**Planning Department
Transportation Development Services Section**

September 4, 2013

Re: **Certification for Permanent Certificate of Occupancy (C.O.)**
Diamond Mesa, Southeast corner of 98th and Gibson Blvd. 2300 Diamond Mesa
DRB Project Number 1002819 (N9-D012)
Units/Bldgs(3401-3406, 3501-3506) Only as referenced within the
Certification Letter Dated 08/28/13

SITE DEVELOPMENT PLAN FOR BUILDING PERMIT DIAMOND MESA

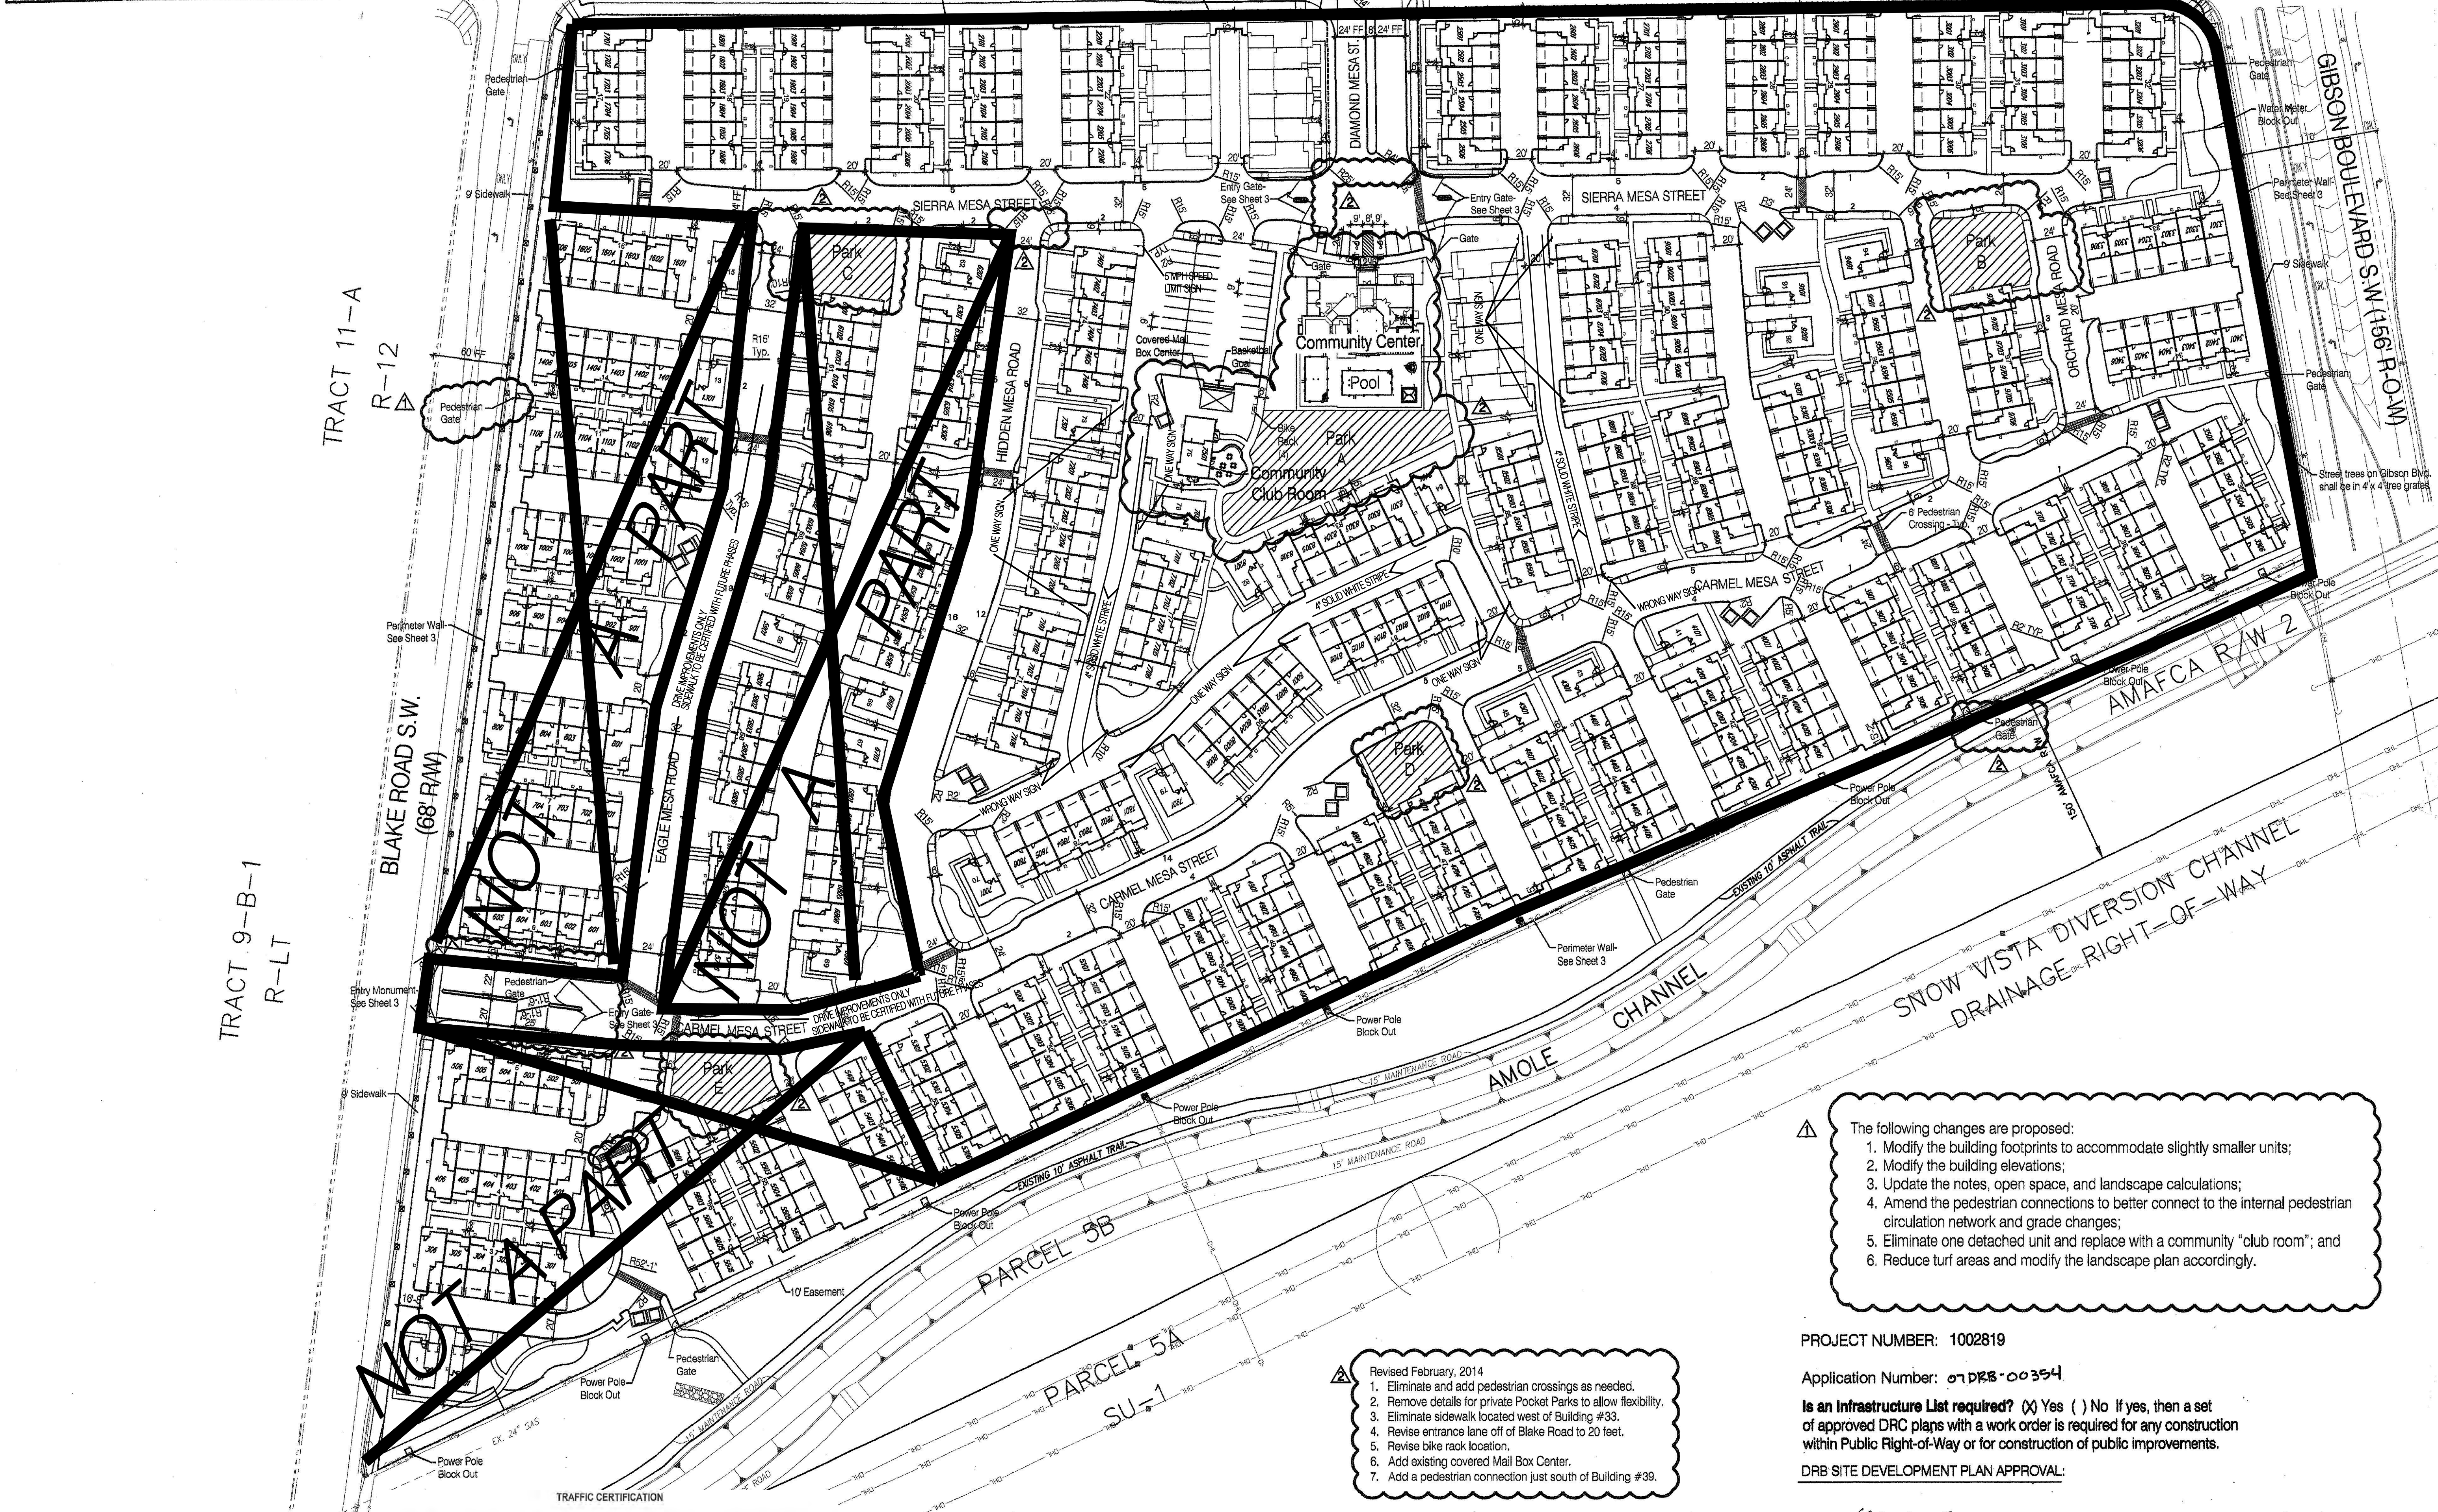
The Certification Letter also requests the inclusion of the previously approved site to include the Club House Building and Buildings: 23-33, 86, 87, 89-97, however, the current site is not in compliance and the following deficiencies need to be addressed:

1. Sidewalk adjacent to Bldg 33 along Orchard Mesa Road is missing,
2. Sidewalk/ADA path to play area in Pocket Park at corner of Sierra Mesa St & Orchard Mesa Rd. is missing, and
3. Crosswalks, three raised, colored concrete crosswalks at Diamond Mesa St entry around Club House are not installed.
